File No: NTH09/01625/30

Your Ref: SSD8169 and MP09\_0028 MOD 3 (Concept Plan)

**State Significant Development Proposal (SSD\_8169) and  
Modification request MP 09\_0028 MOD 3 (Concept Plan) North Byron Parklands Cultural Events Site, Yelgun.**

CIVIL WORKS PLAN

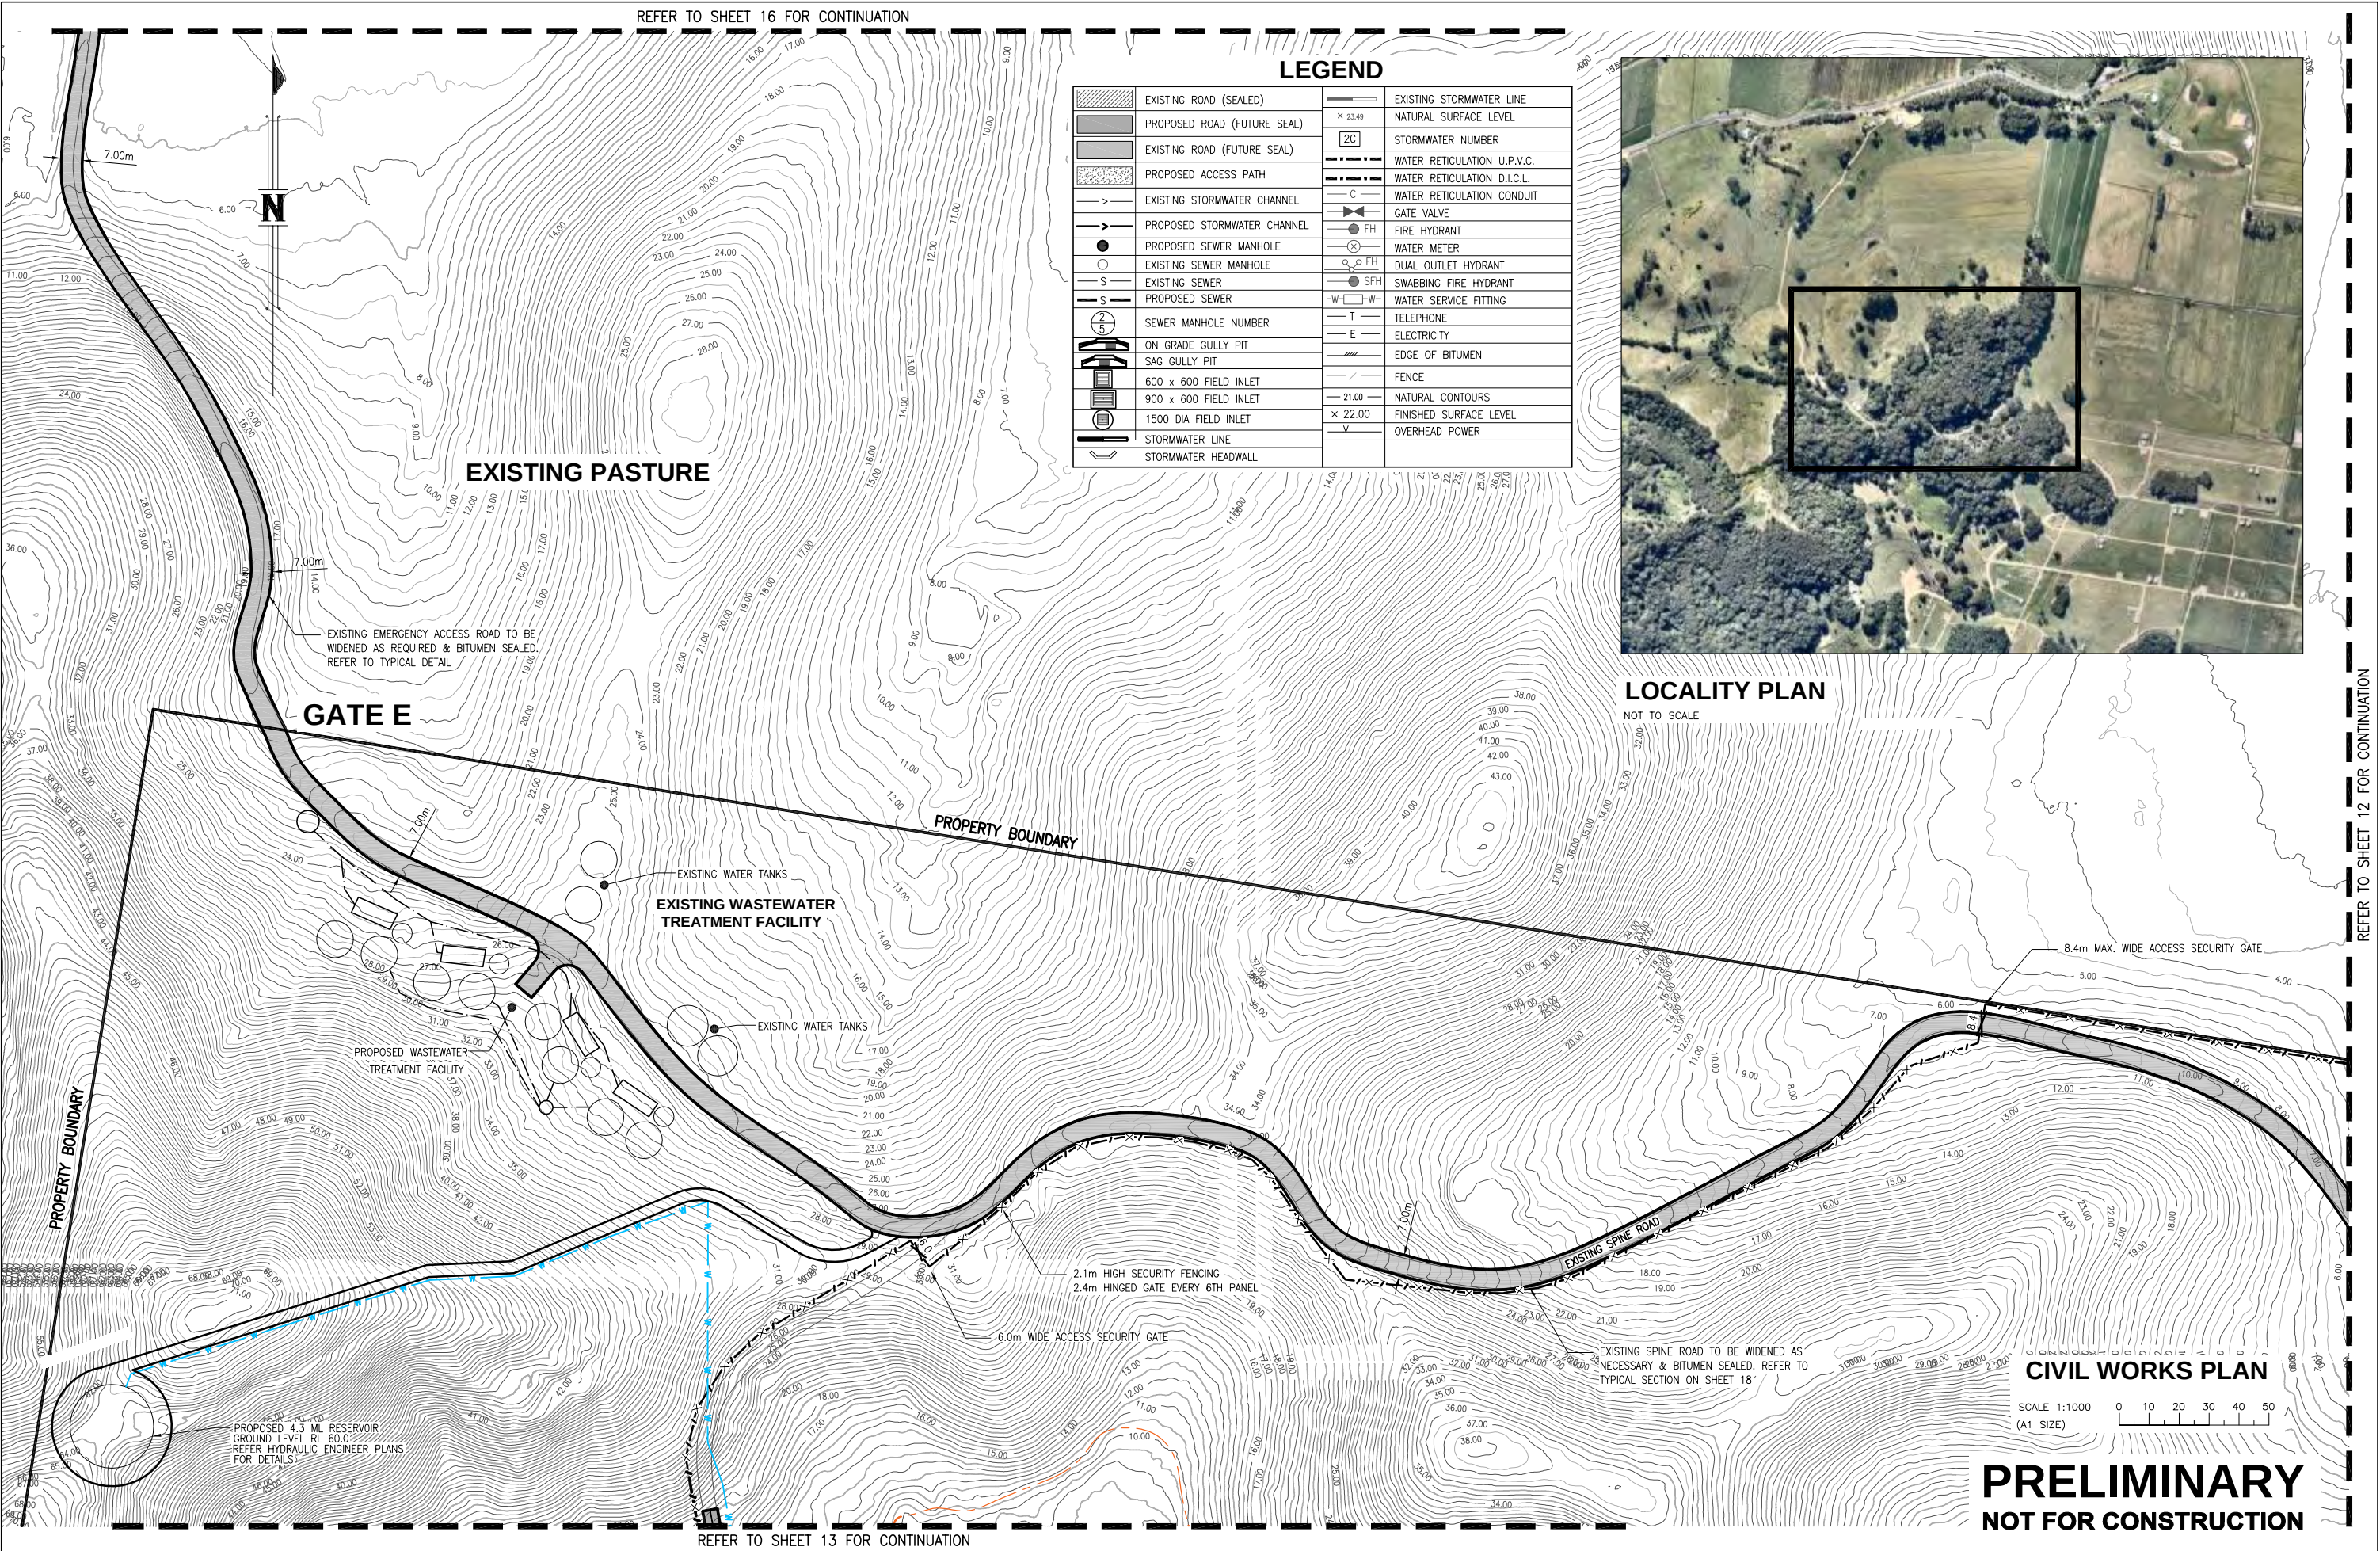
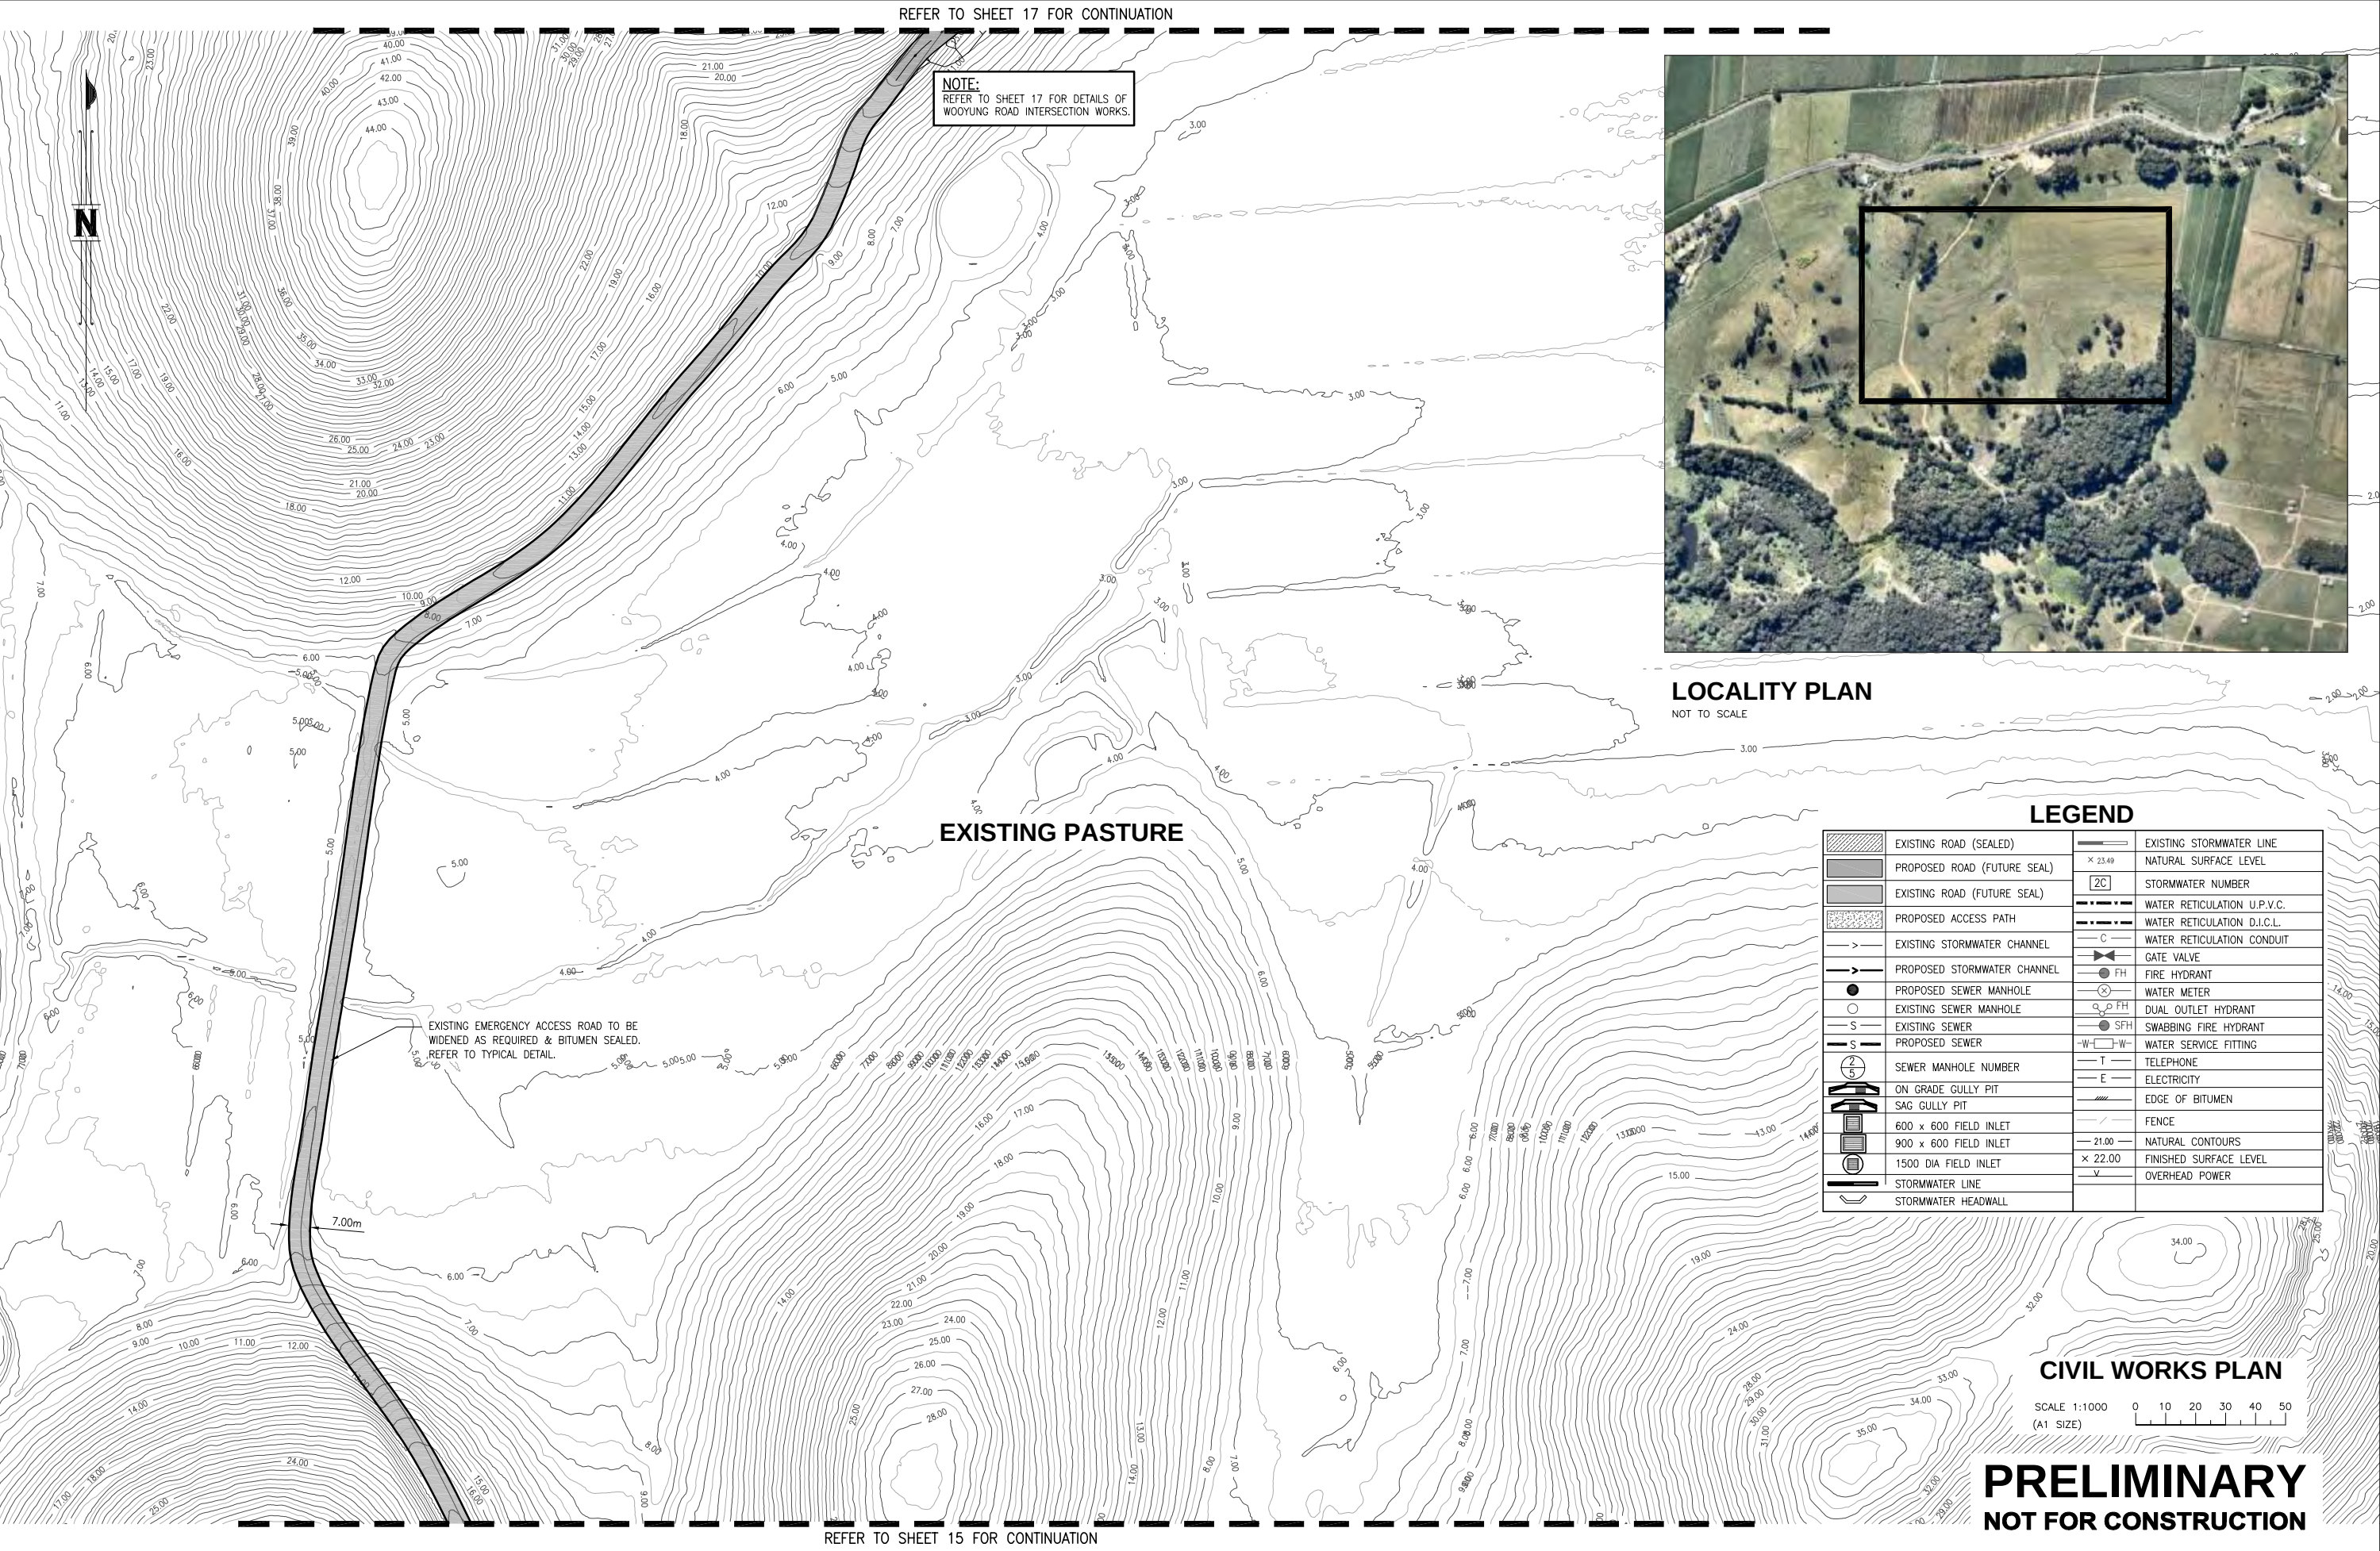
- Previously Gate E Wooyung Road has been used under the direction of NSW Police getting vehicles off the site during bump-out. This is proposed to become a camper and day patron entry and exit for parking only for vehicles arriving from the Tweed Coast Road. Clarification is required for the works proposed at Wooyung Road intersection and its use for parking.
